Application number: 2020/91978	
What is the application for?:	Part demolition of boundary wall to form new off road parking space (within a Co
Address of the site or building:	22, Town Head, Honley, Holmfirth, HD9 6BW
Postcode:	WF14 8EA

SITE PLAN AS PROPOSED

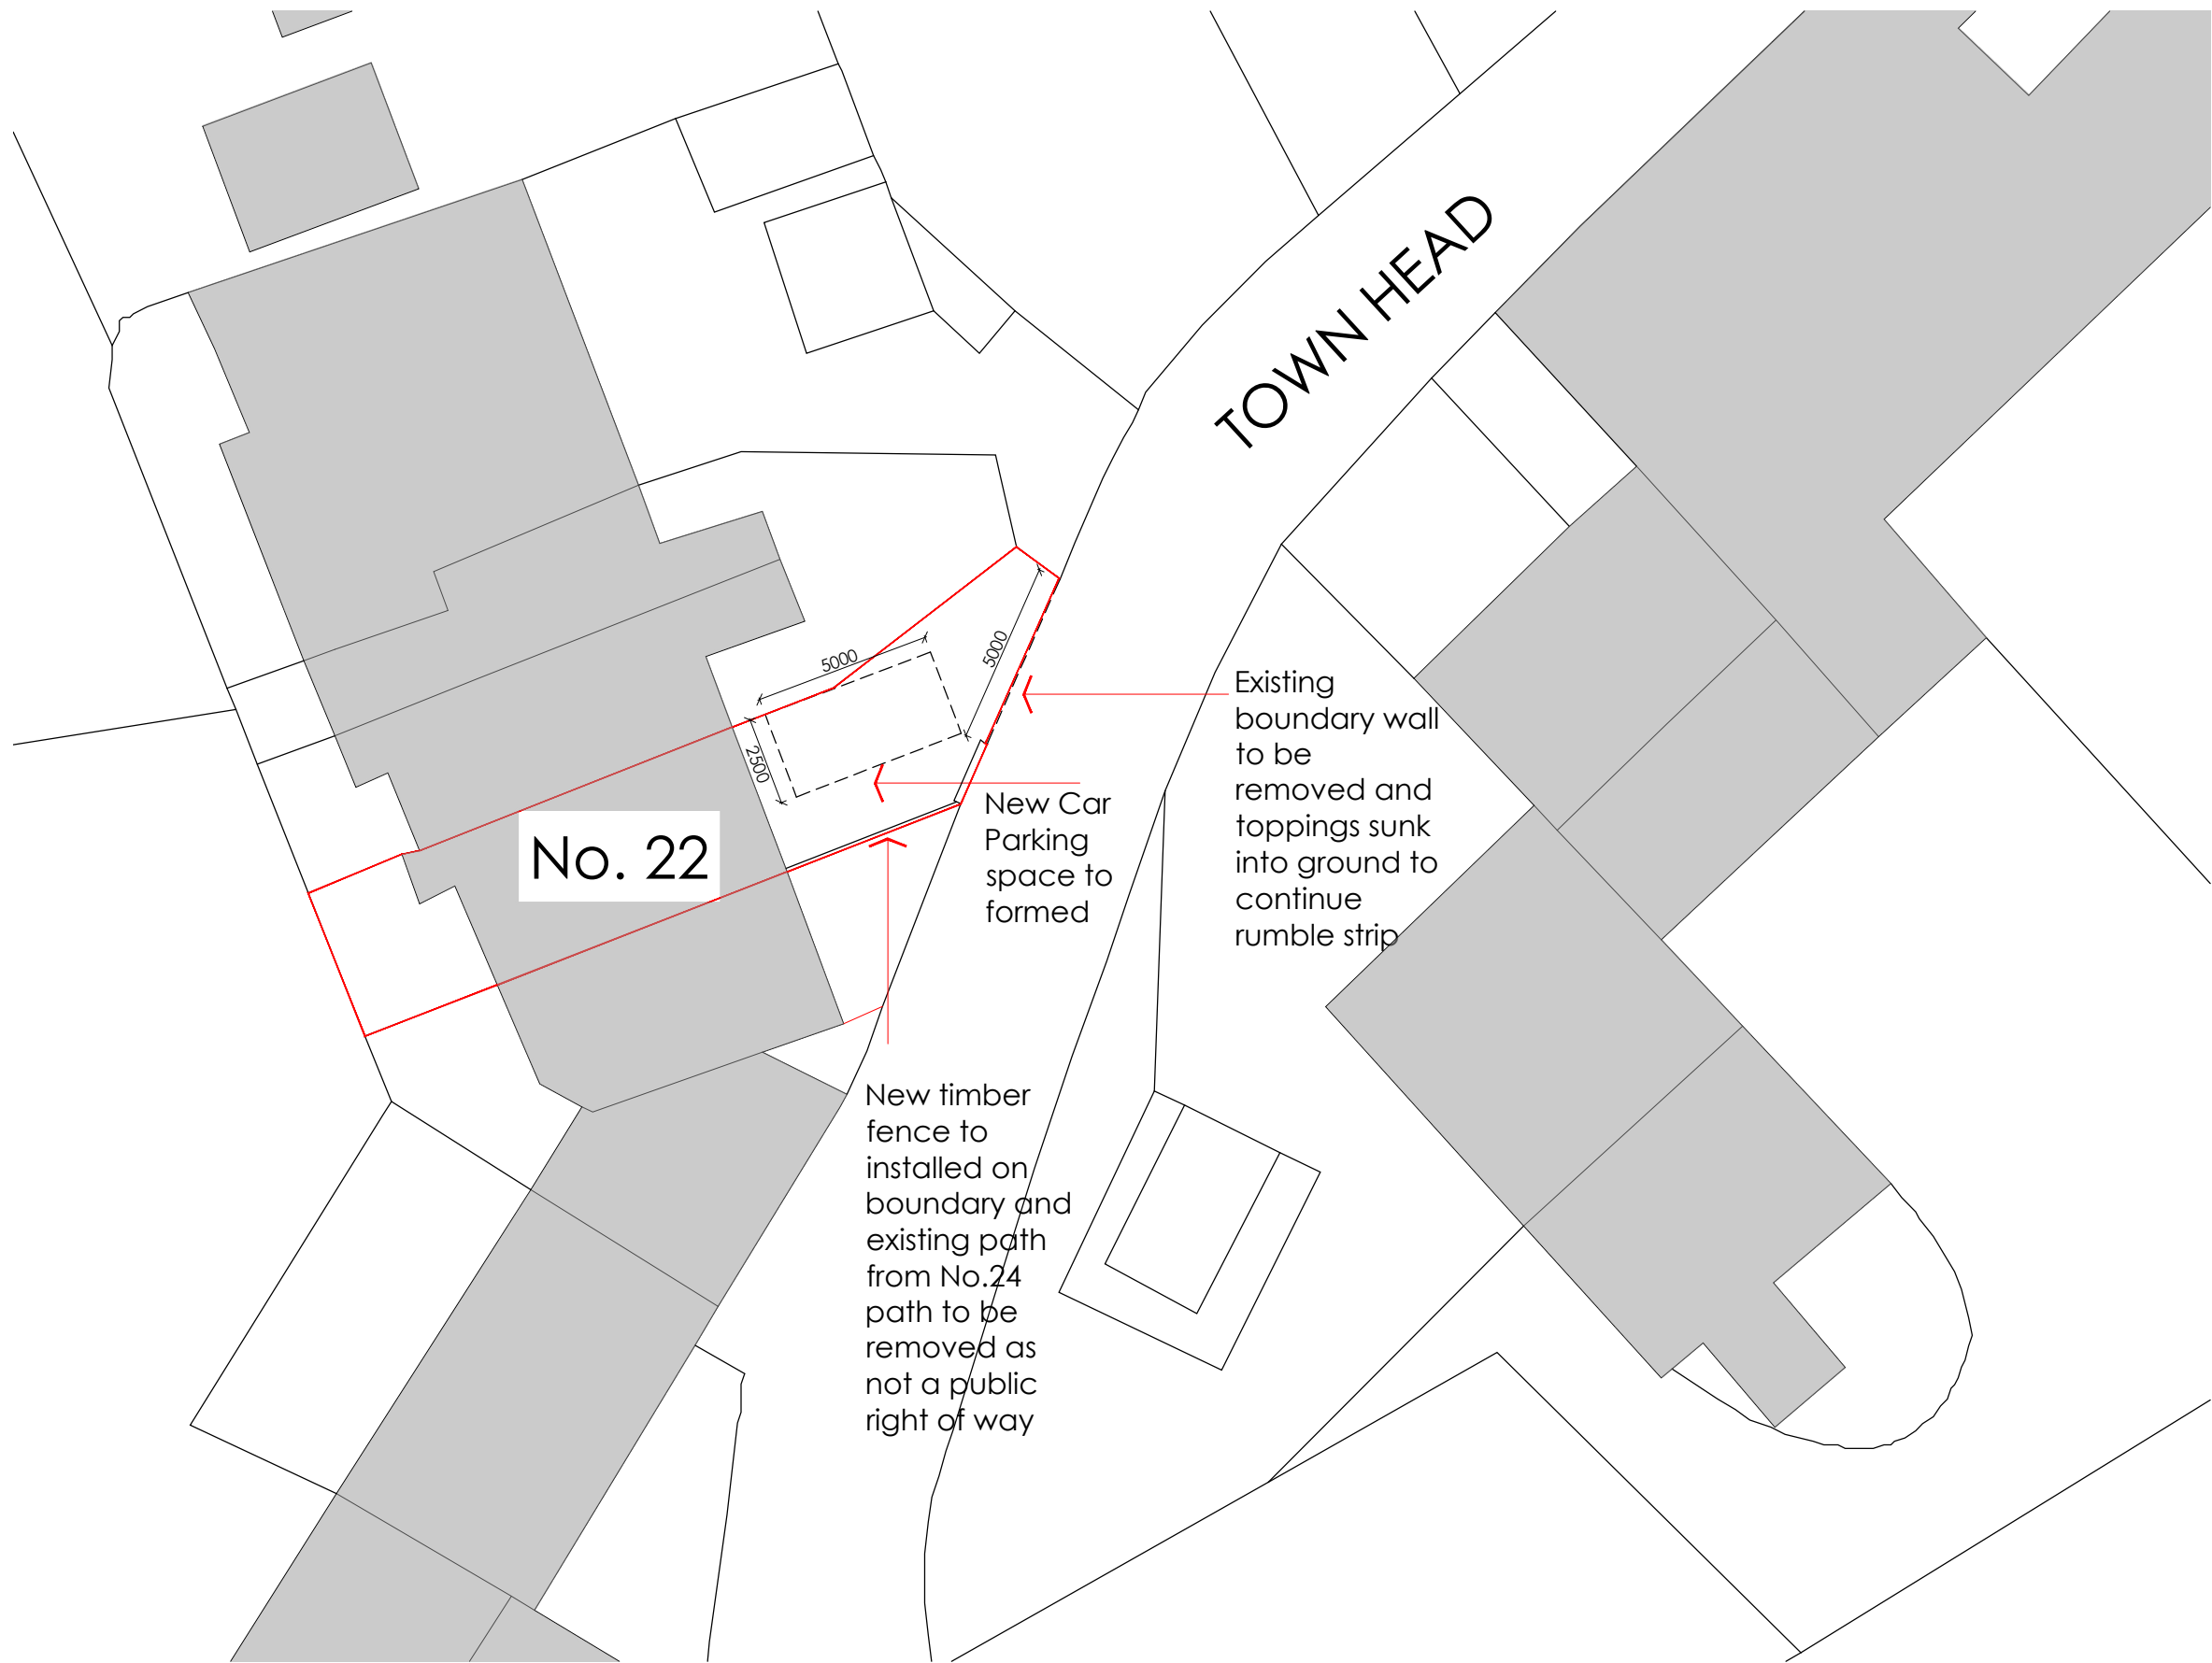
Type of comment: An objection
As a neighbour, I object to the application. 1). The proposal to (partly) demolish the dry stone wall would spoil and destroy the character of what is a conservation area. The dry stone walls are a unique feature of Yorkshire villages and should be preserved. A precedent should not be set with the demolition of these features for personal gain. 2). Being an adjacent neighbour, the use of the garden as a parking space would cause further problems and disruption. Much of the view from the front window of the property looks out across the garden of no.22 towards the village, A small car would partially block this view but a larger car and especially a van would entirely block the view, and crucially block out light. Having a vehicle parked only a few feet from the main front window of my property is something I strongly oppose as it would also cause further issues of engine noise, privacy, disturbance and exhaust fumes. 3). Creating off-road parking for one car would create more problems than it solves. The road is narrow and cars already use the other side of road to park. Creating an opening with the demolition of the dry stone wall would mean space would have to be left for manoeuvring into the property and therefore losing at least one on-street parking space.
